Please ask for: Mrs D Johnson
Email: daun.johnson@arun.gov.uk
Telephone: 01903 737762
Our Ref: BE/119/20/PL
Your Ref:
Date: 20th October 2020

Application for Planning Permission

Development: 1 No. detached house. This site is in CIL Zone 1 (Zero Rated) for new dwelling.
Location: Land West Of New Barn Lane Bersted PO21 5DN

CLIENT:	Bellway Homes Ltd (Wessex)	PROJECT:	Land West of Newbarn Lane, North Bersted
SCALE:	1:100 (A1 ORIGINAL)	DRAWING:	Plot 51 - Proposed Layout & Supporting Information
DRAWN: SA	18256	P201	—
DATE: Aug 2020

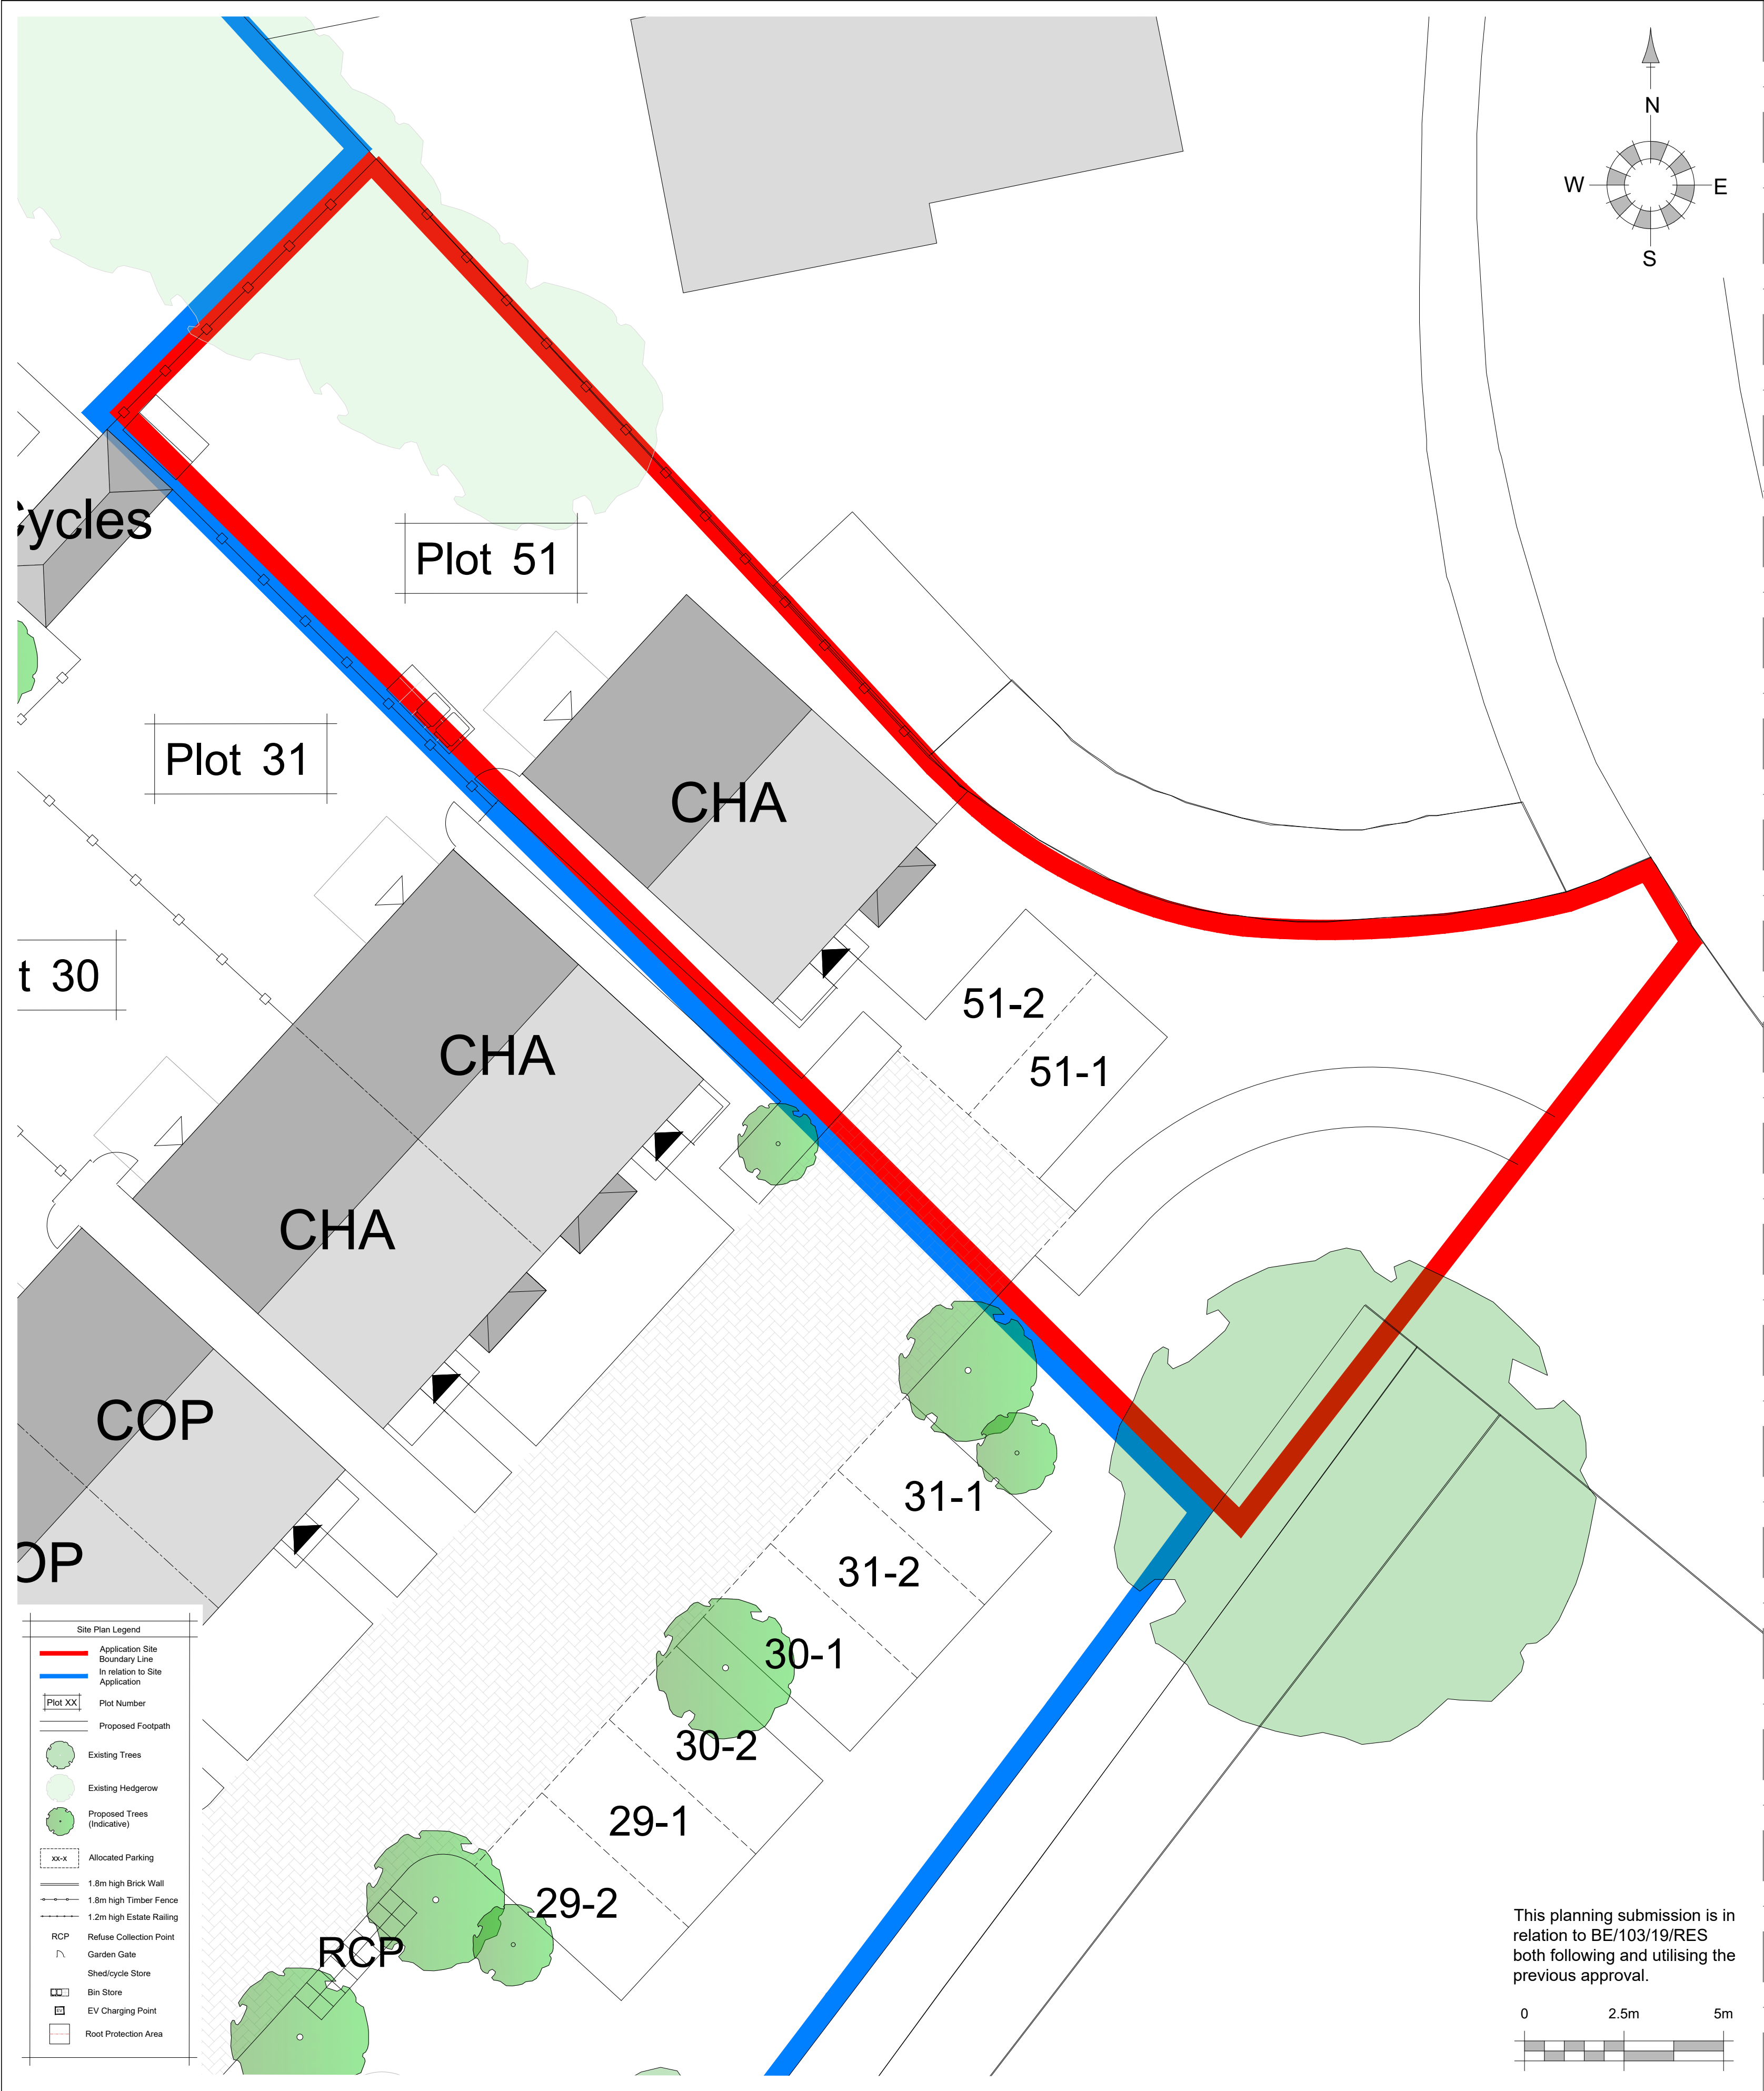
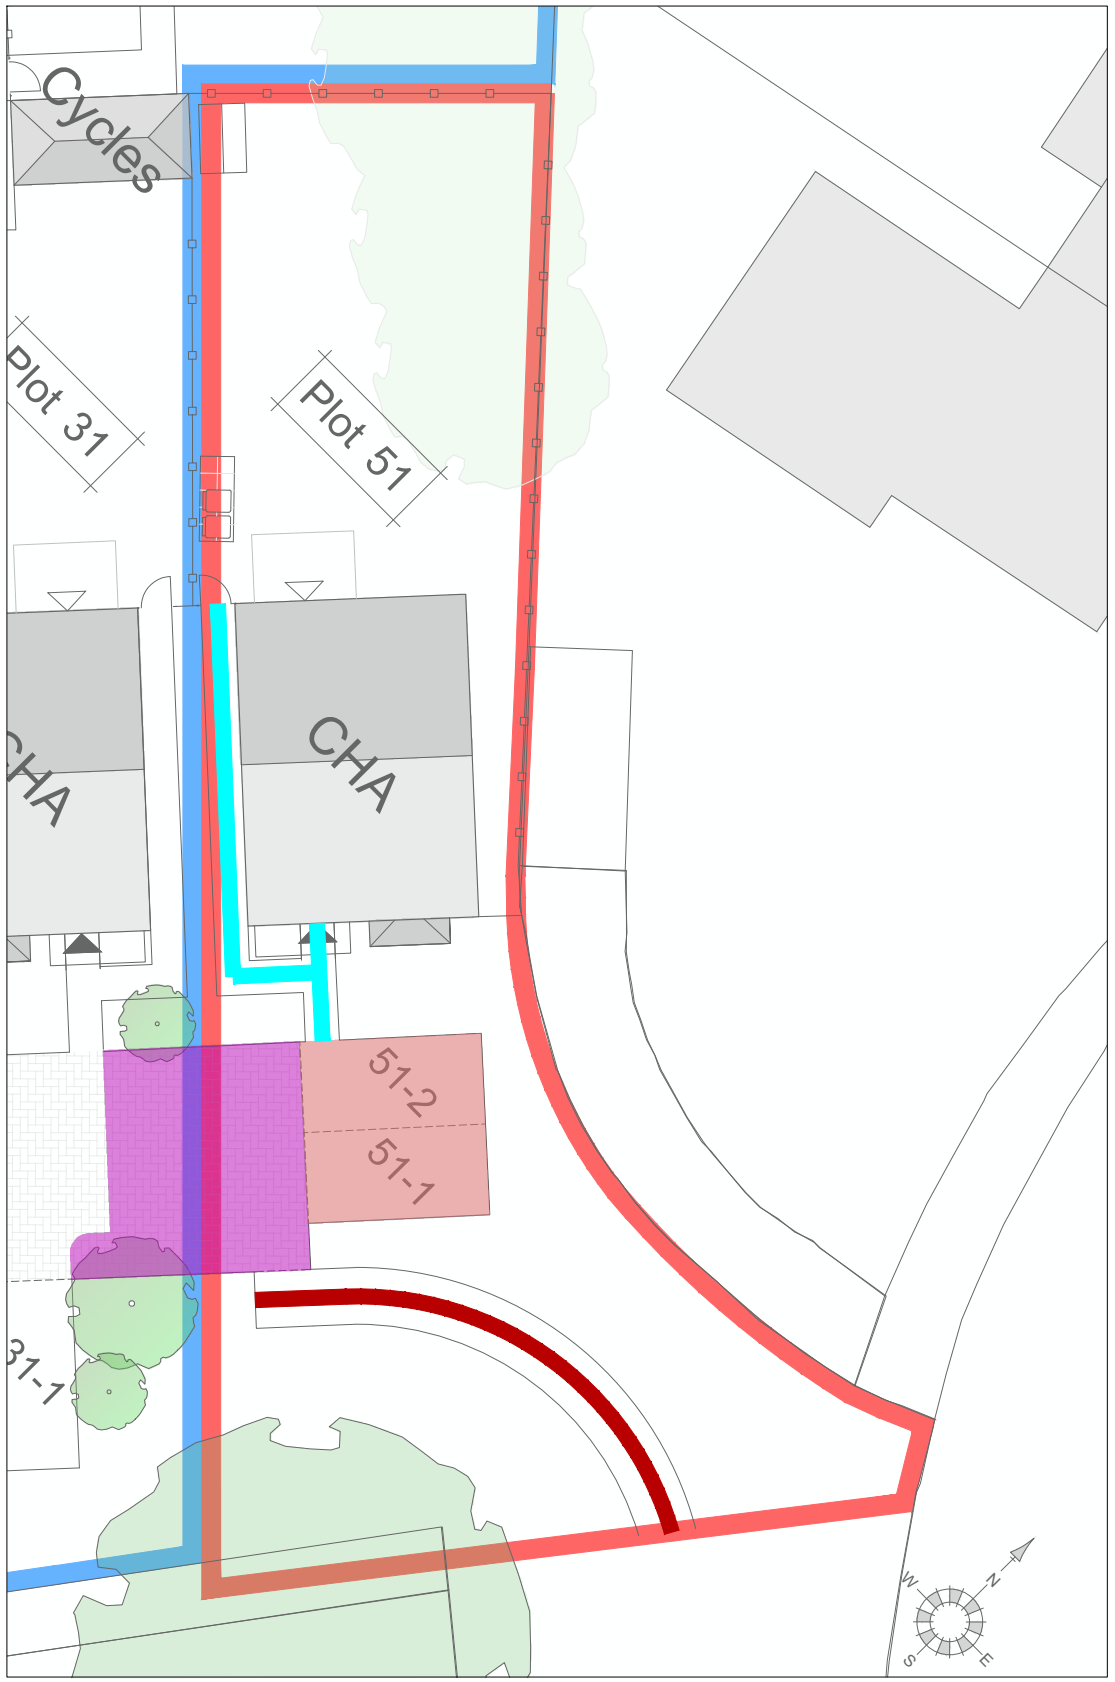
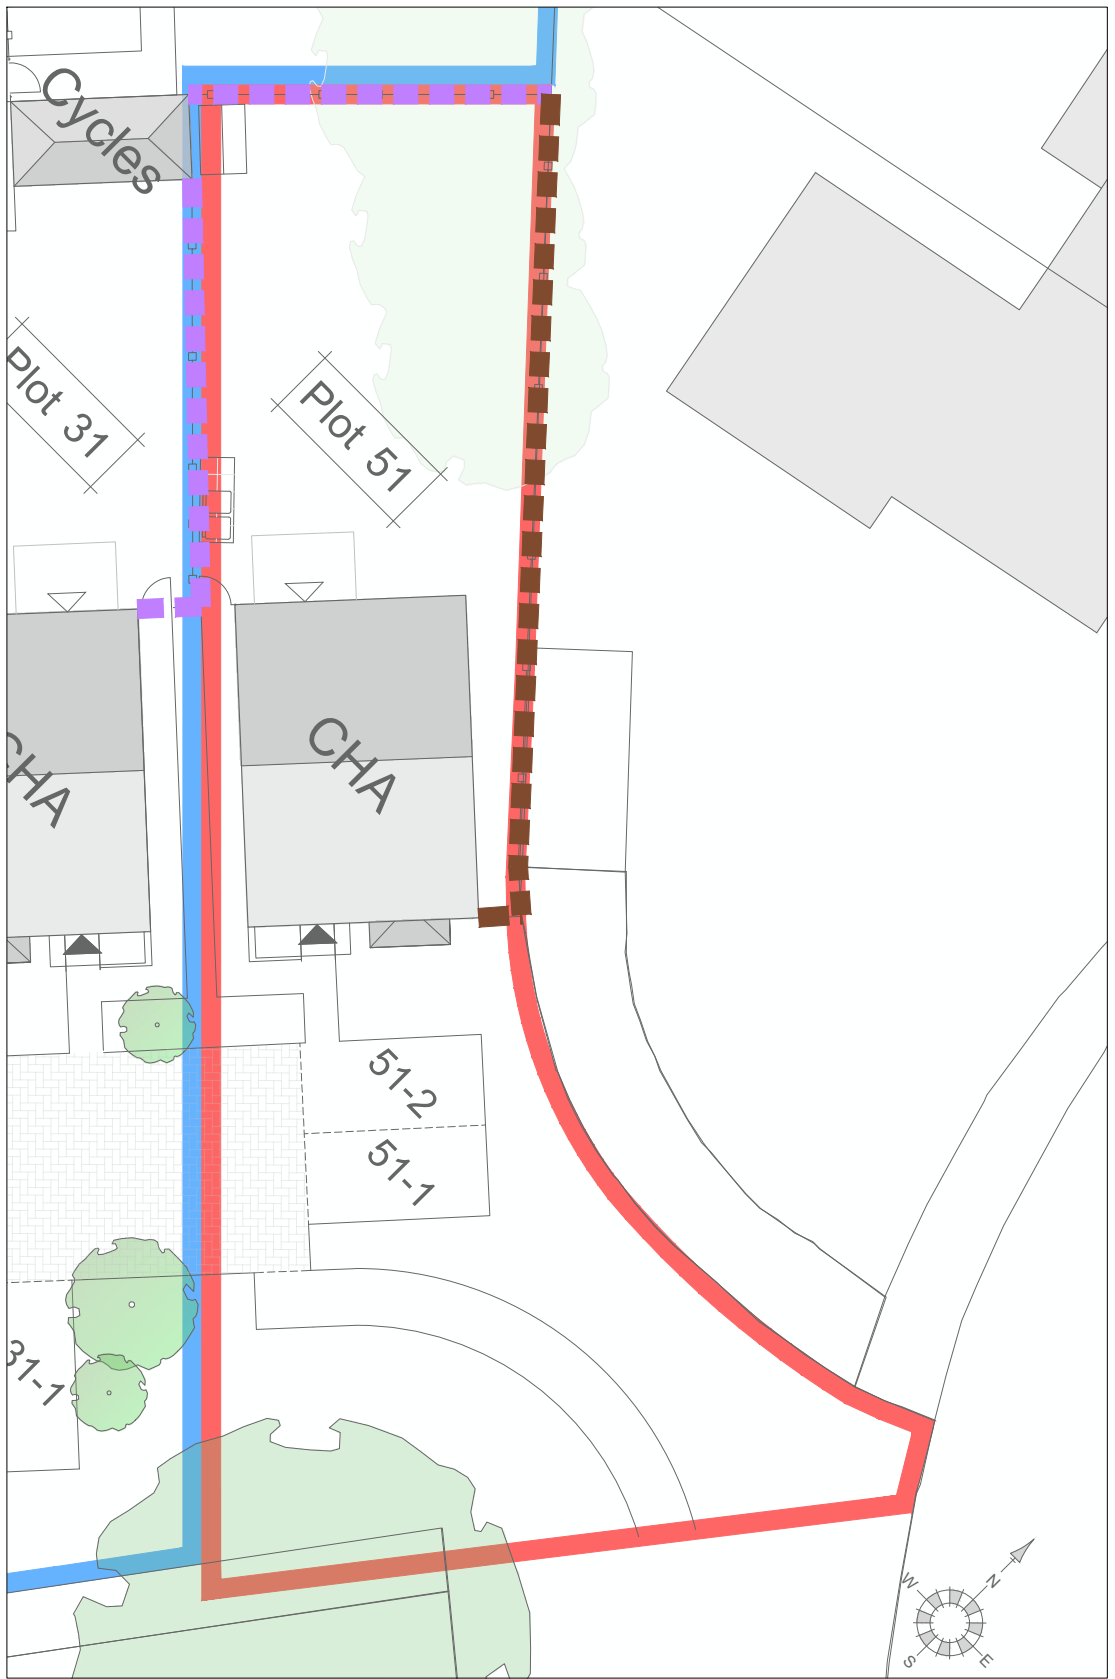
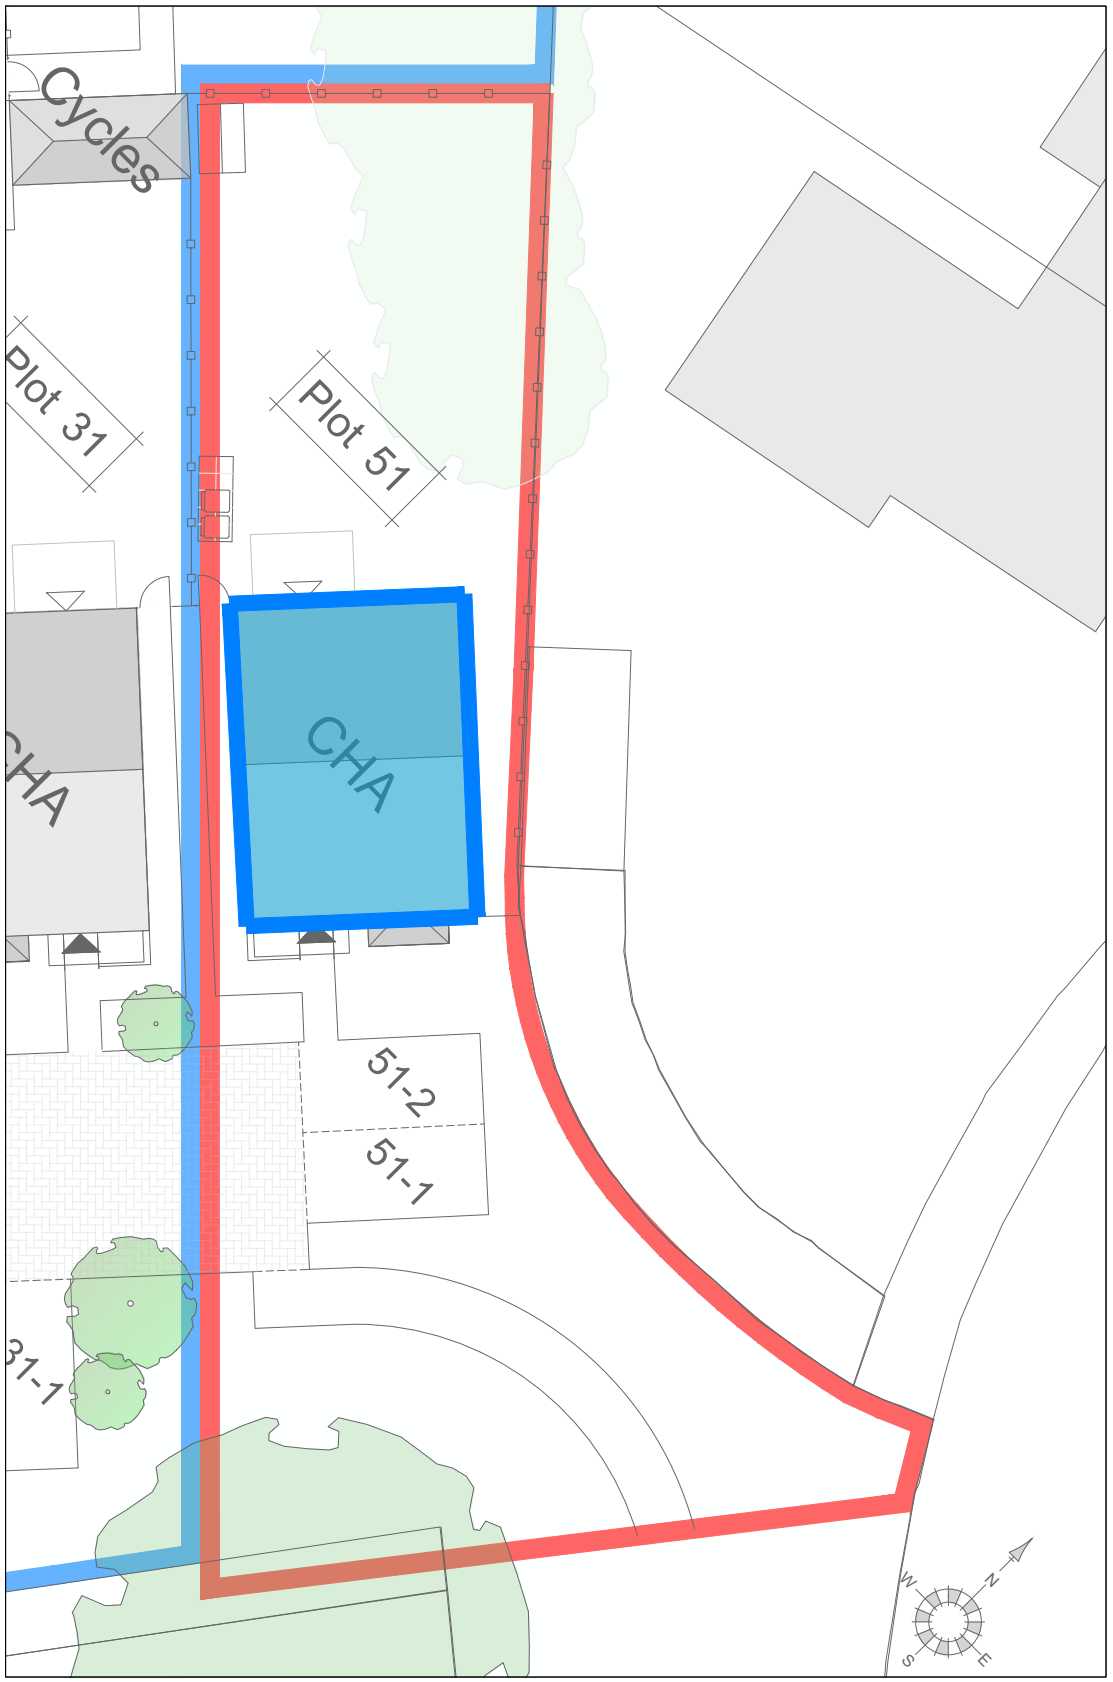
On the Block plan, please provide measurements from the proposal to the site boundaries and show the access from the road to the proposal.
